CITY OF ALBUQUERQUE

RE: **Entertainment Facility**
3930 Pan-American NE
Conceptual Grading and Drainage Plan
Engineers Stamp Date: 5/3/2018
Hydrology File: G16D145A

Based on the information provided in the submittal received on 5/5/25/2018 the above-referenced Conceptual Grading and Drainage Plan is approved for Site Plan for Building Permit. Prior to approval of the Grading and Drainage Plan for Building Permit the following comments must be addressed:

GRADING PLAN

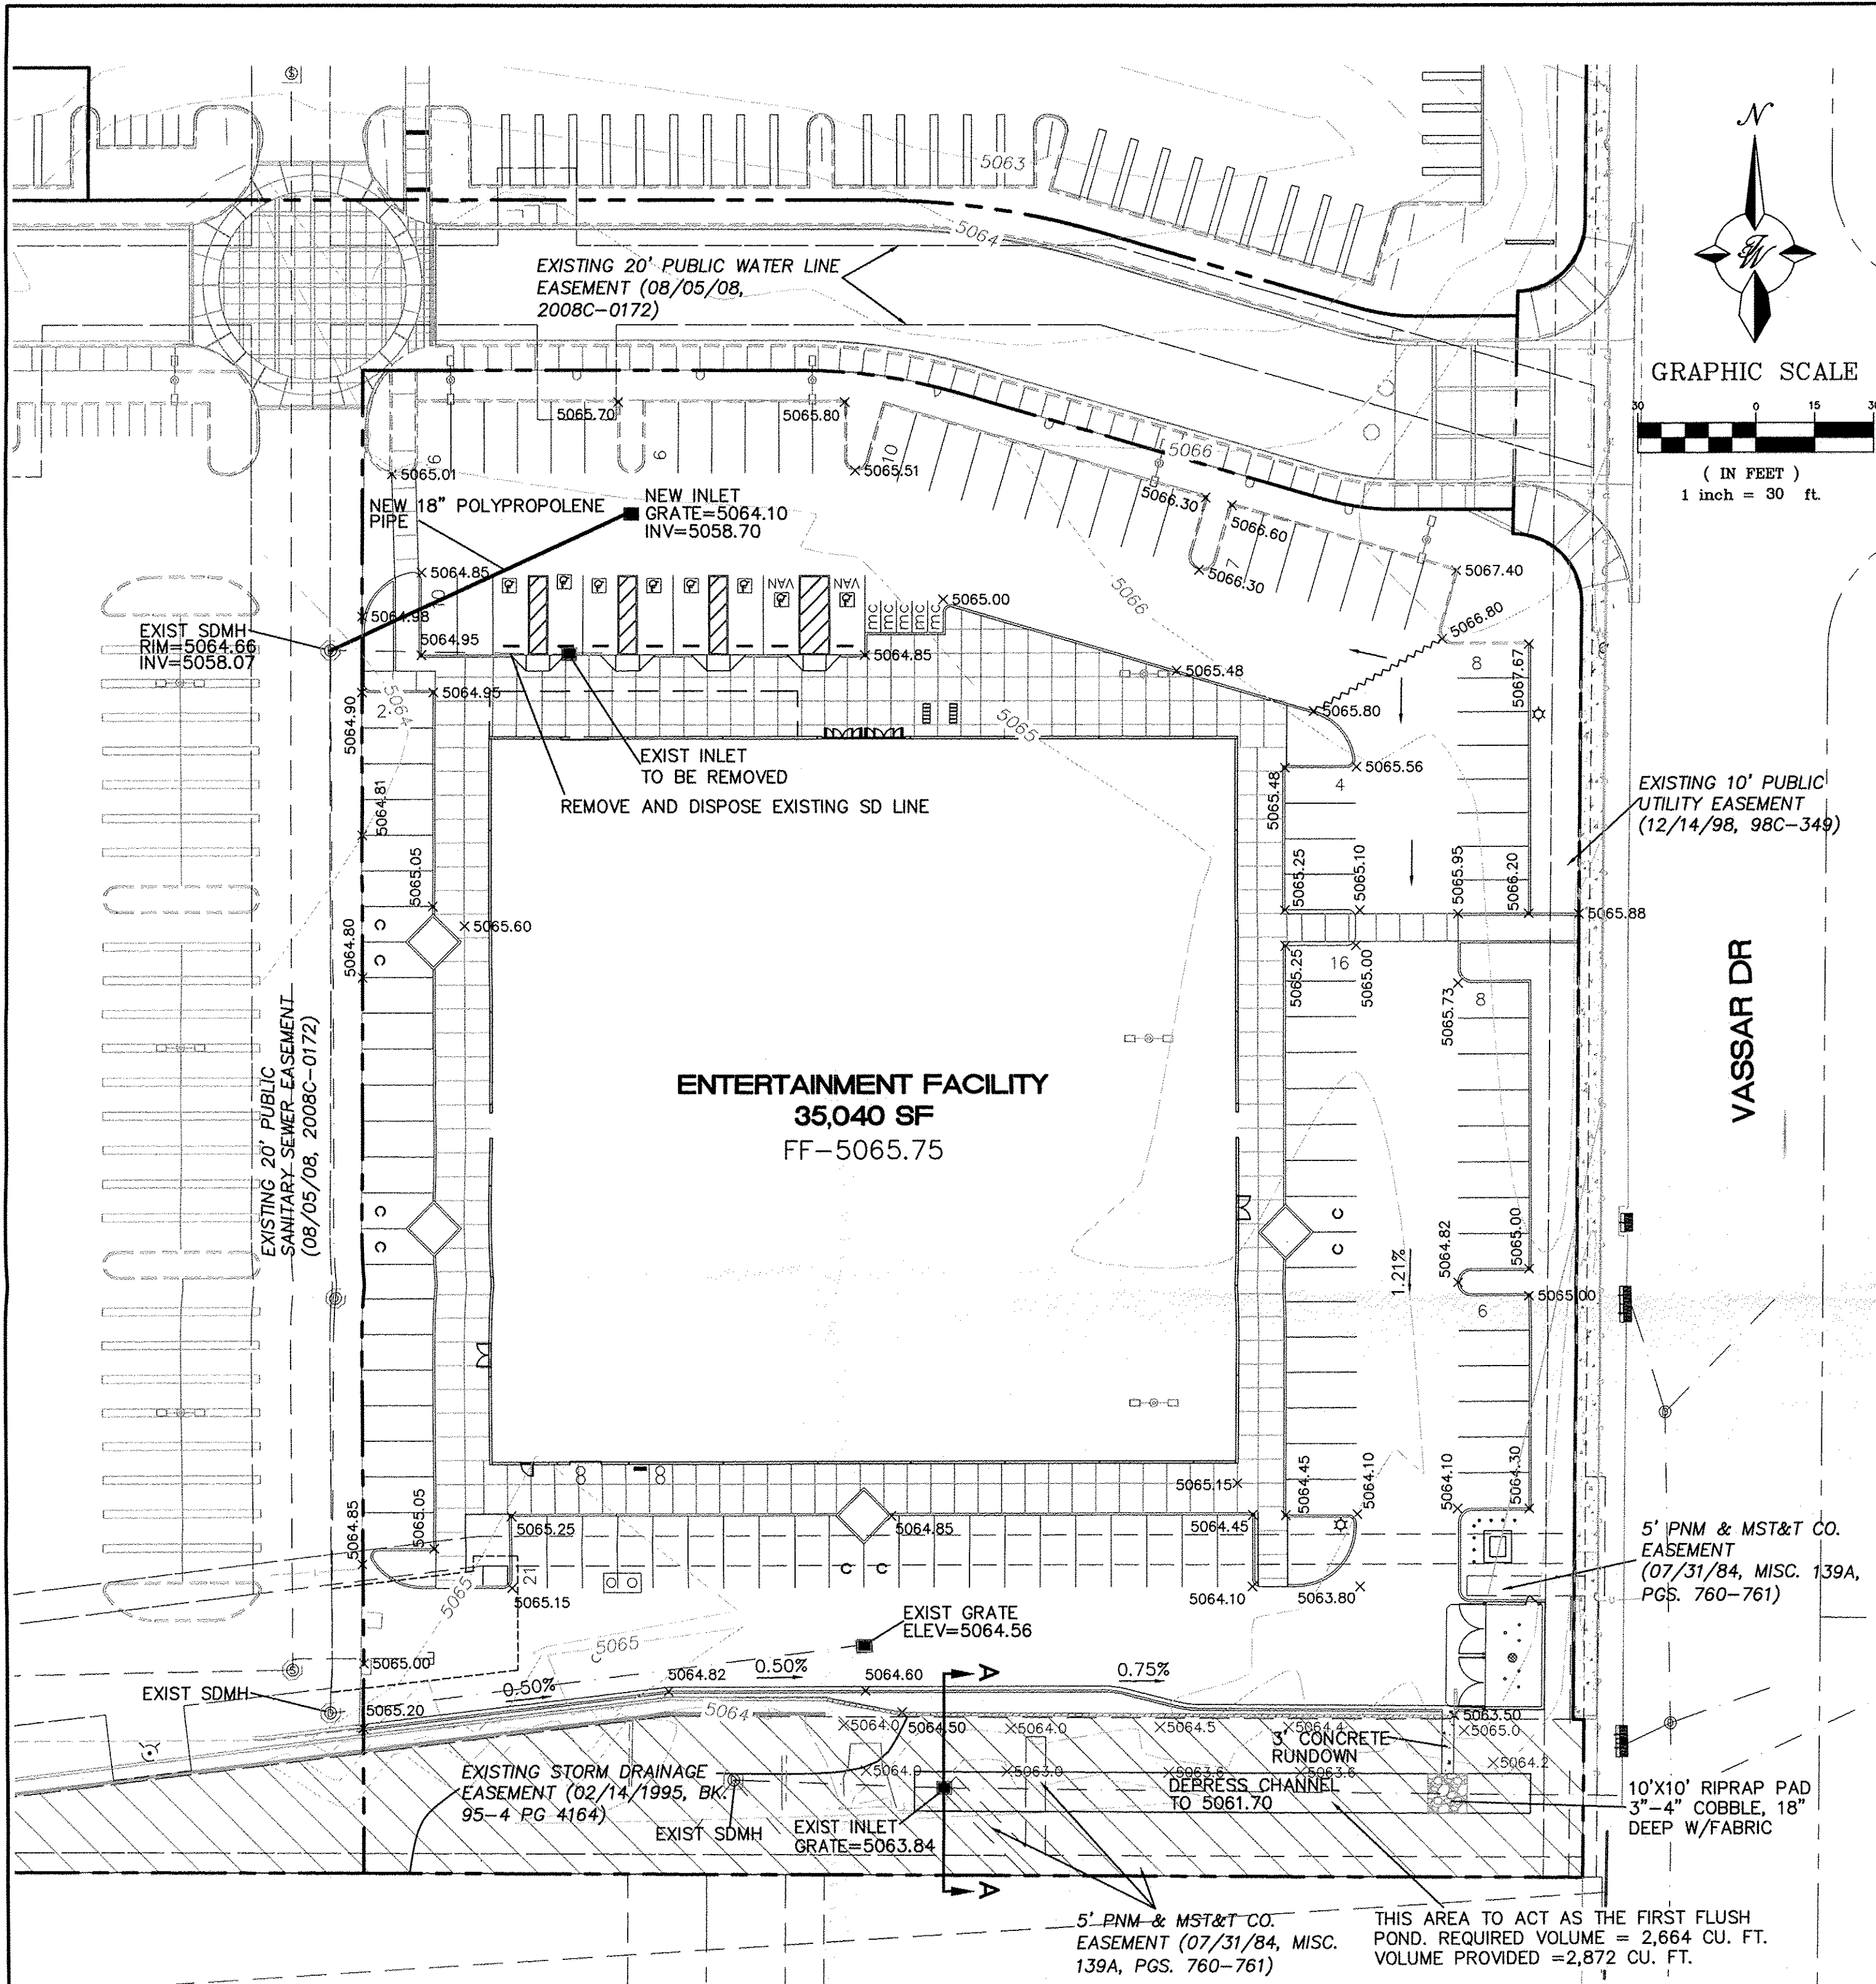
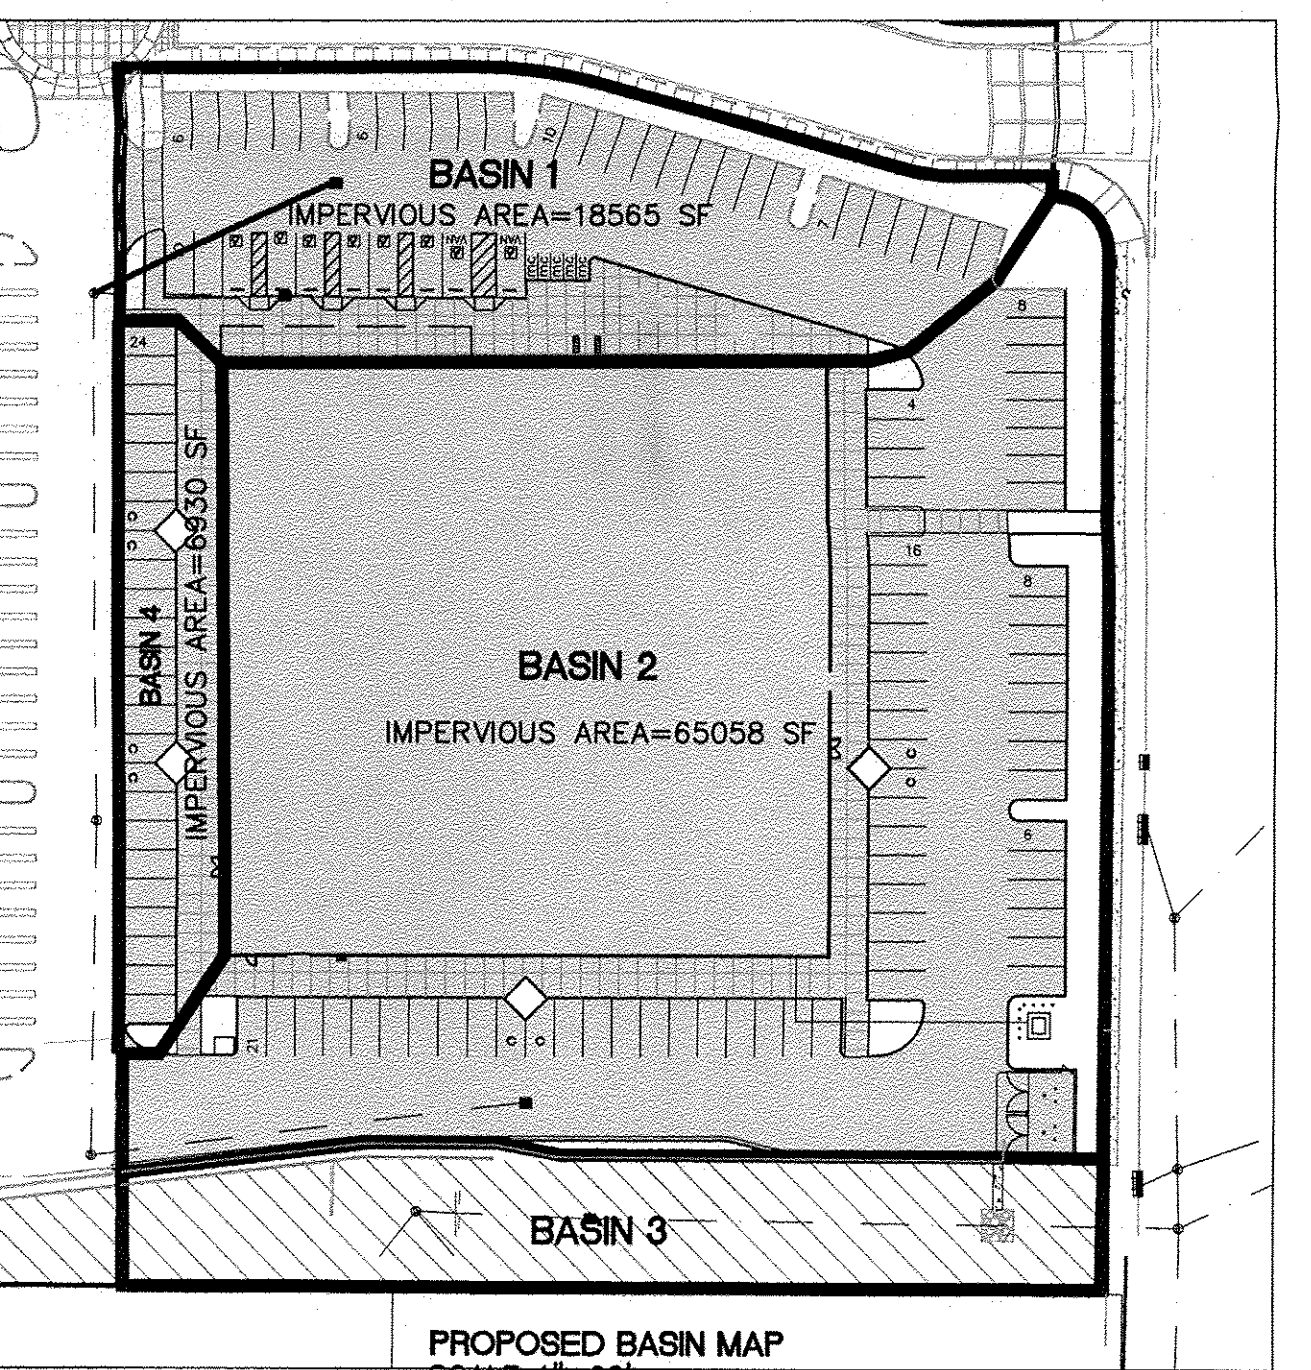
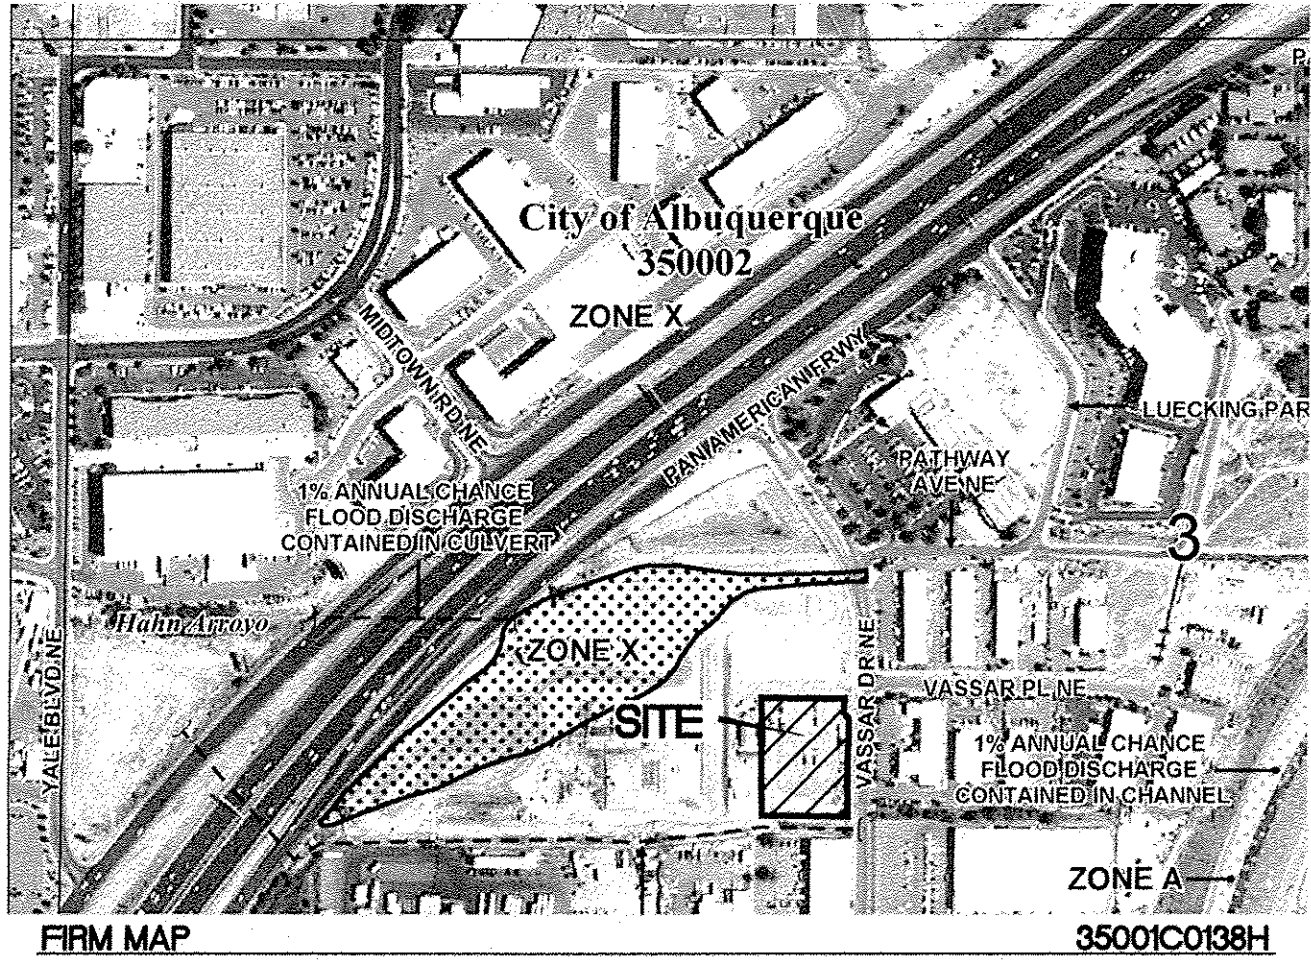
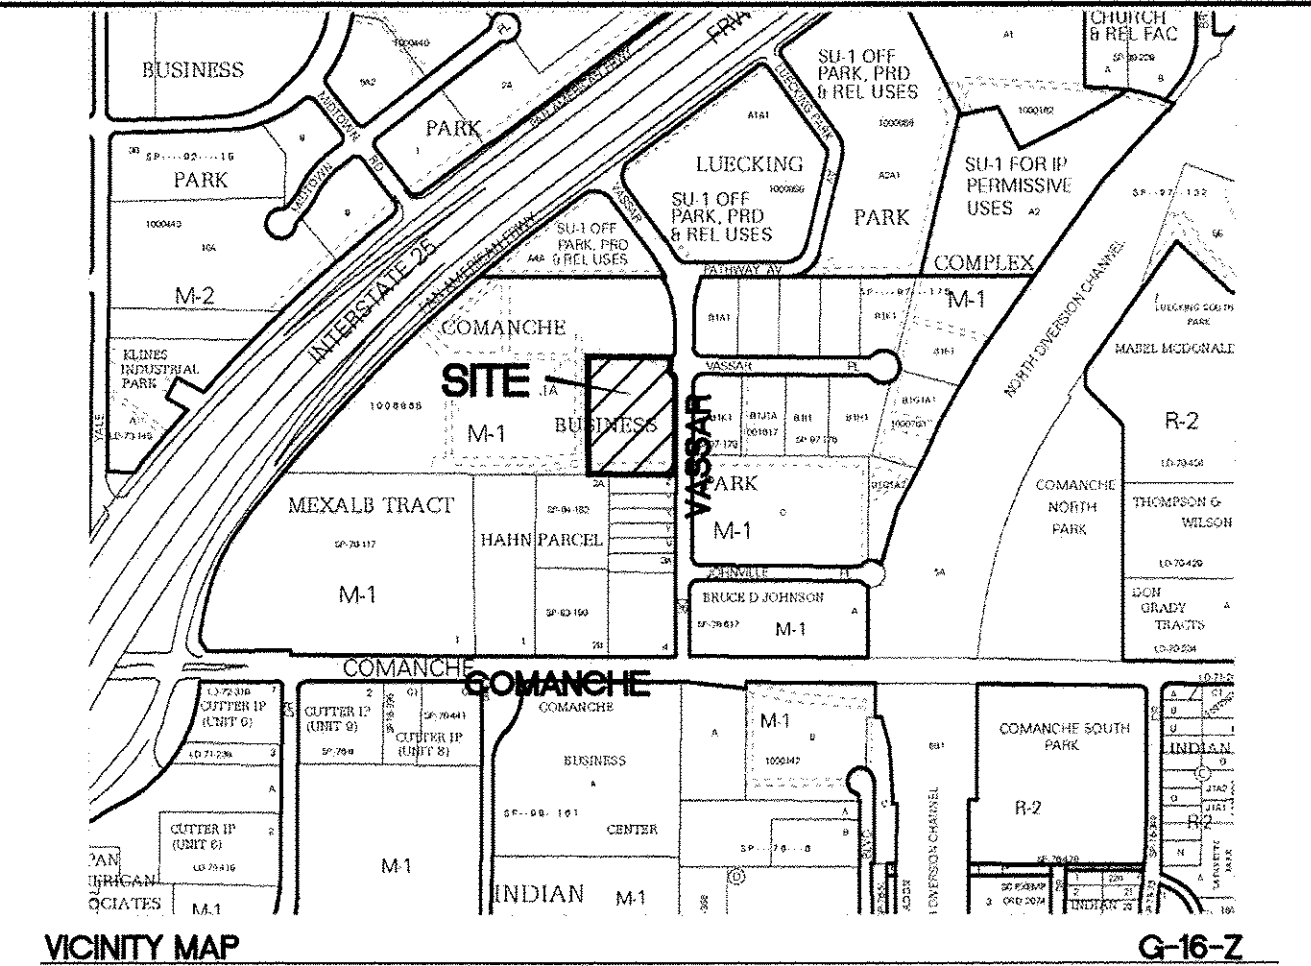
1. First Flush volume calculations are required for the volume provided by the onsite pond. They should be based on dimensioned details, so the slopes inside the pond should be labeled on Section AA and the proposed contours in the plan view should be located to agree with the slopes shown on the cross section. Labels are not legible on some of the contours.
2. Details of the existing and proposed drainage structures in the onsite pond need to be added to the plan along with capacity calculations. A detail of the existing primary pond outfall structure must include construction specifications for modifications to prevent floatables from leaving the pond during the 100 year peak flow without clogging and calculations must be included demonstrating that the 100 year flow depth at the primary outlet will remain below the crest elevation of the existing concrete dam.
